From: Mike Ablett [REDACTED]
Sent: 11 September 2020 18:50
To: Maria Tomalova <Maria.Tomalova@arun.gov.uk>
Cc: Ben Lamb [REDACTED]
Subject: Re: 17 Nyewood Lane, Bognor AW/151/20/PL

Thankyou for your call and advice. We would like to withdraw our application for 17 Nyewood Lane, Bognor AW/151/20/PL and will be resubmitting a new application for an 8 bed HMO.

The drawings which you have provided are to scale, however it entirely different proposal than that was submitted originally.

GROUND FLOOR
APPROX. FLOOR
AREA 1021 SQ.FT.
(94.9 SQ.M.)

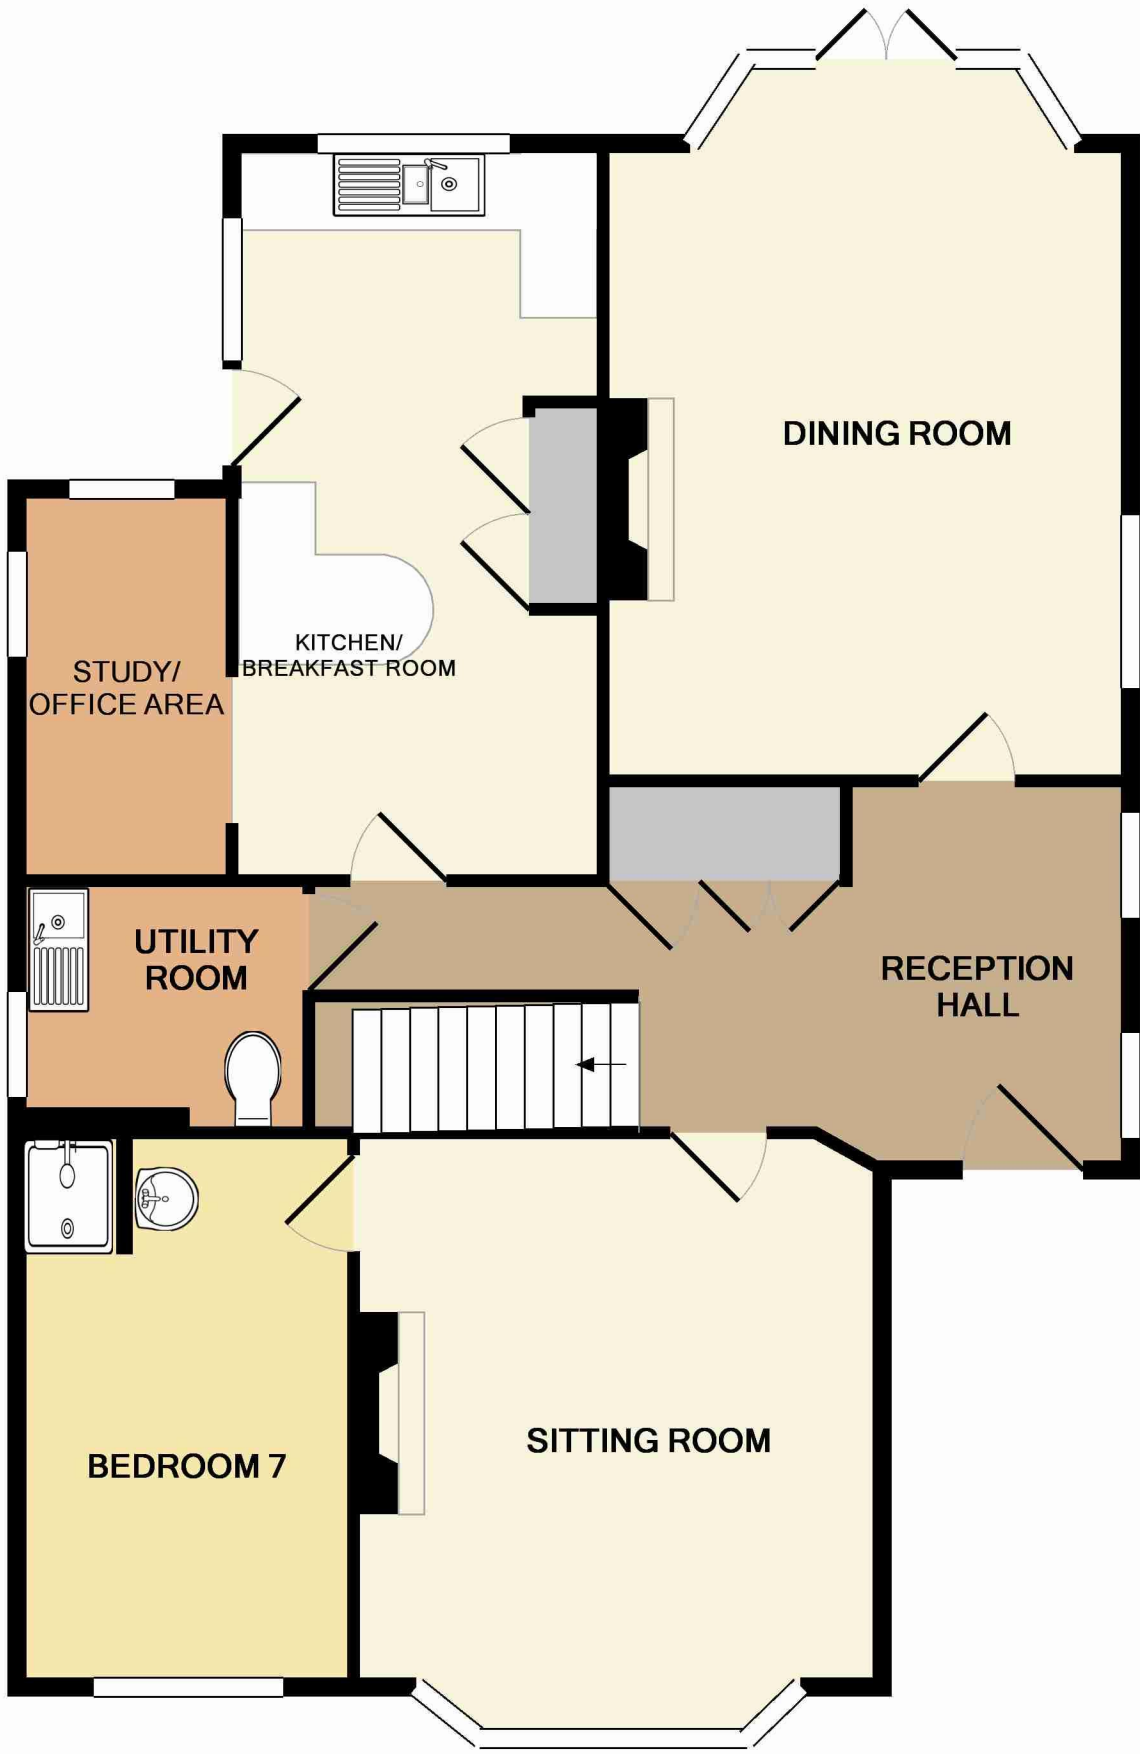
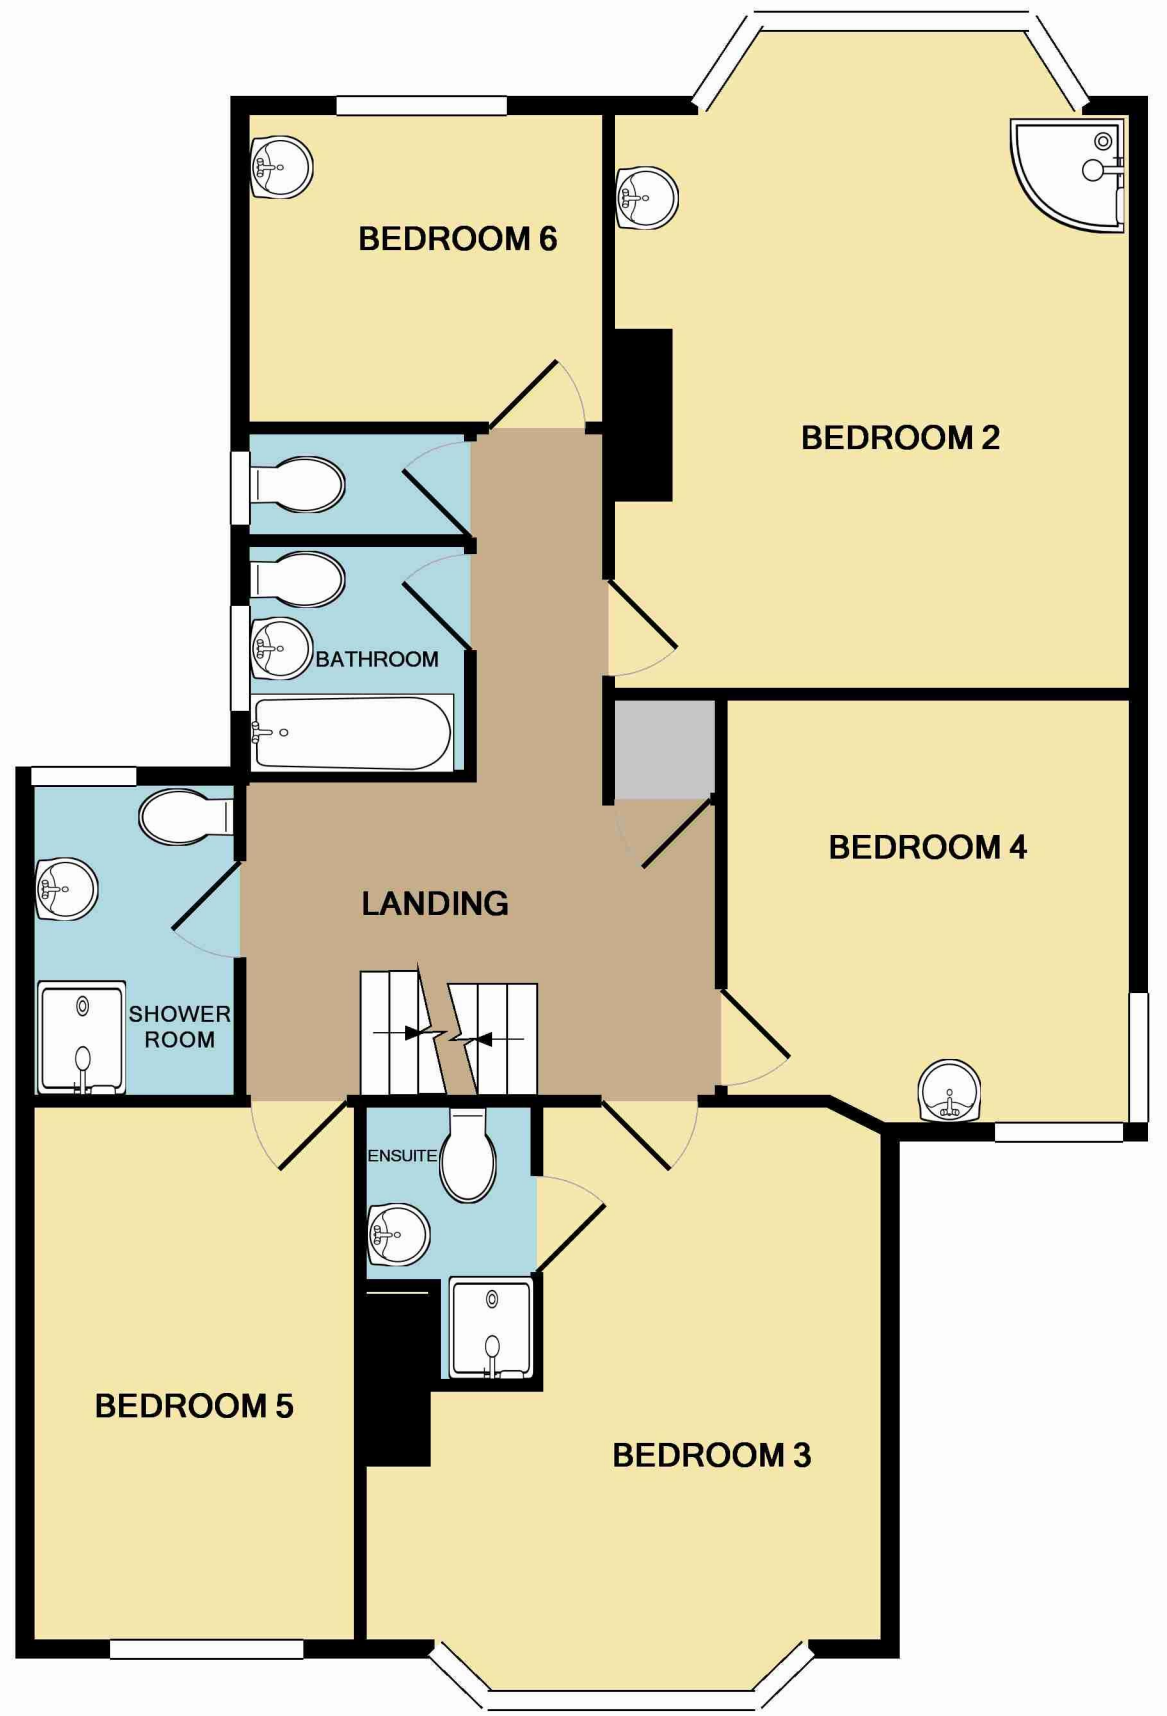
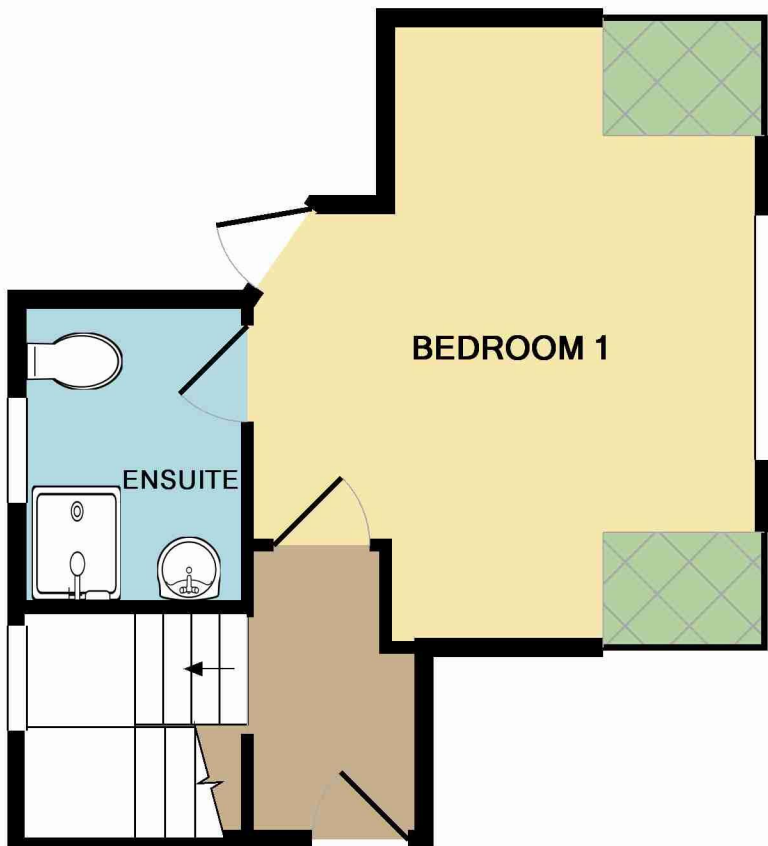
Submitted drawings show 7 bedrooms from which 2 are ensuite and 5 bedrooms share 2 bathrooms together with sitting, a spacious dining room and kitchen.

Currently sent to scale drawings show 9 bedrooms from which 2 are ensuite and 7 bedrooms share 2 bathrooms. In addition, there is no dining, no sitting room just kitchen with rather undersized (for 9 people) dining area.

Proposal as amended are not acceptable. What we were asking for drawings to scale, we haven't agreed with amendments.

The kitchen/diner does meet minimum sizes for nine persons.

Apart from the two en-suite Rooms there are four toilets and a bath and shower available that meet the needs of the residents.
